Re: Observation of Strategic Housing Development Application.

An Bord Pleanála Case reference: TA06D.313281

Applicant: Cairn Homes Properties Limited

Description of Development: Demolition of 'Winterbrook', and the former dwelling attached to Barrington Tower (a protected structure), Brennanstown Road, Dublin 18 - construction of 534 no. Build to Rent apartments, creche and associated site works.

Drawing Title: Proposed Floor Plans - Block J - Lower Ground Floor to Second Floor Plan

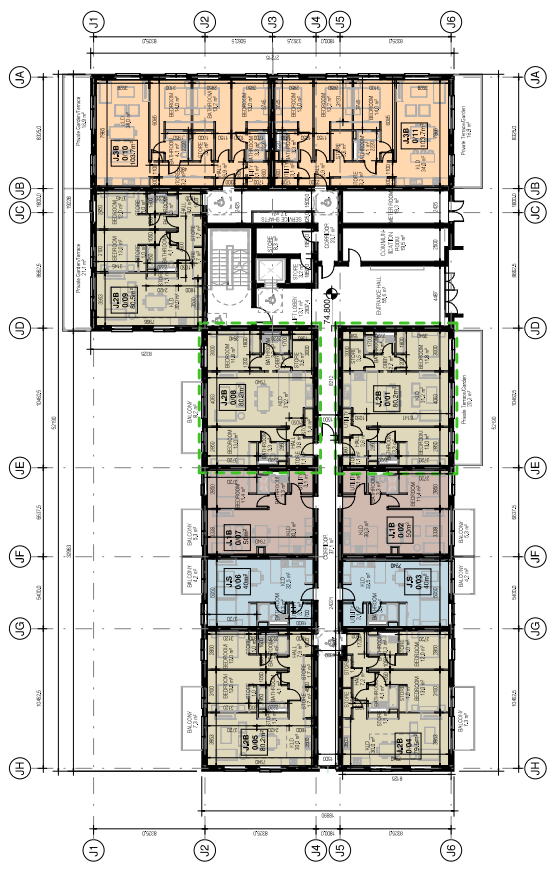
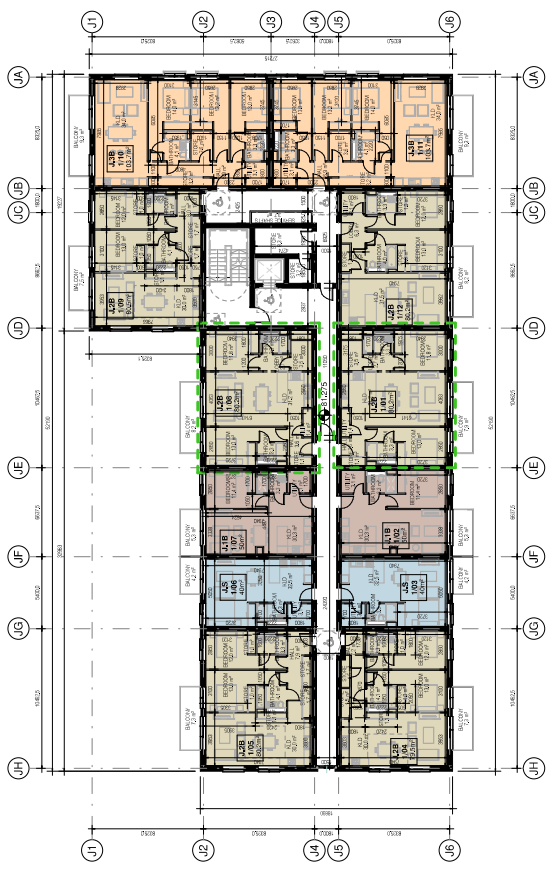
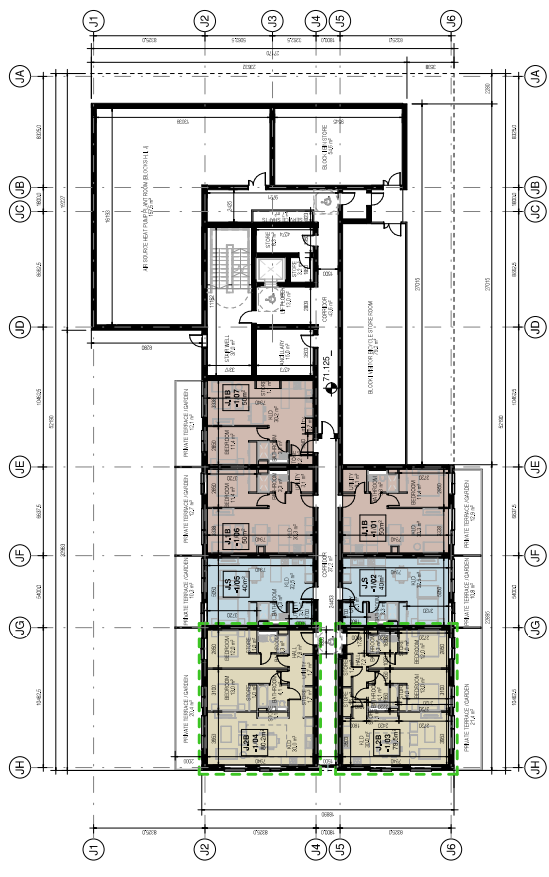
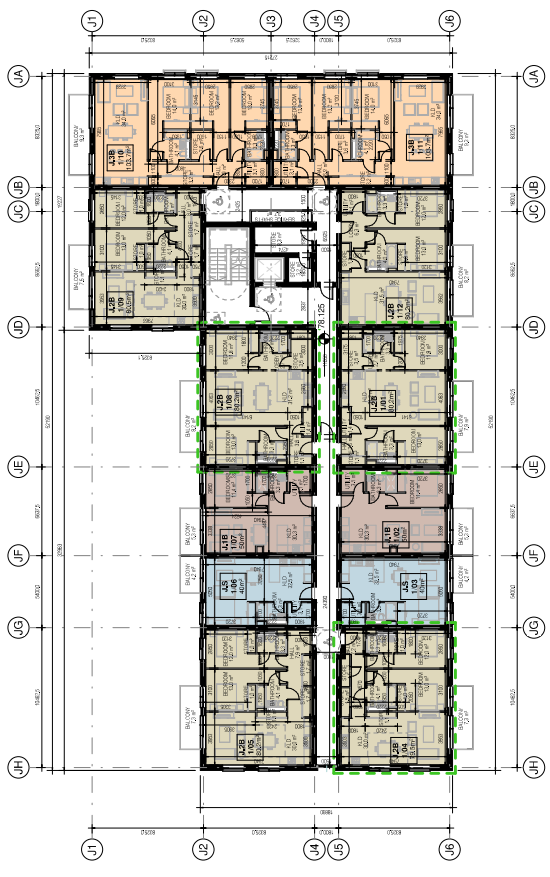
- The visual overbearance of the 6 - 7 Storey Block I (which will rise to c. 14m over the ridge height of our home, and which will be relatively close to our shared boundary).
- The negative impact on our garden and all our habitable rooms with east facing windows (including our kitchen & main bedroom) due to **over shadowing** and **loss of light** given the proximity, height and massing of Block J relative to our home.
- **Loss of privacy** by way of direct over-looking into our kitchen, main bedroom, and front / rear gardens (from both windows and overhanging balconies on the western and southern elevation of Block J).
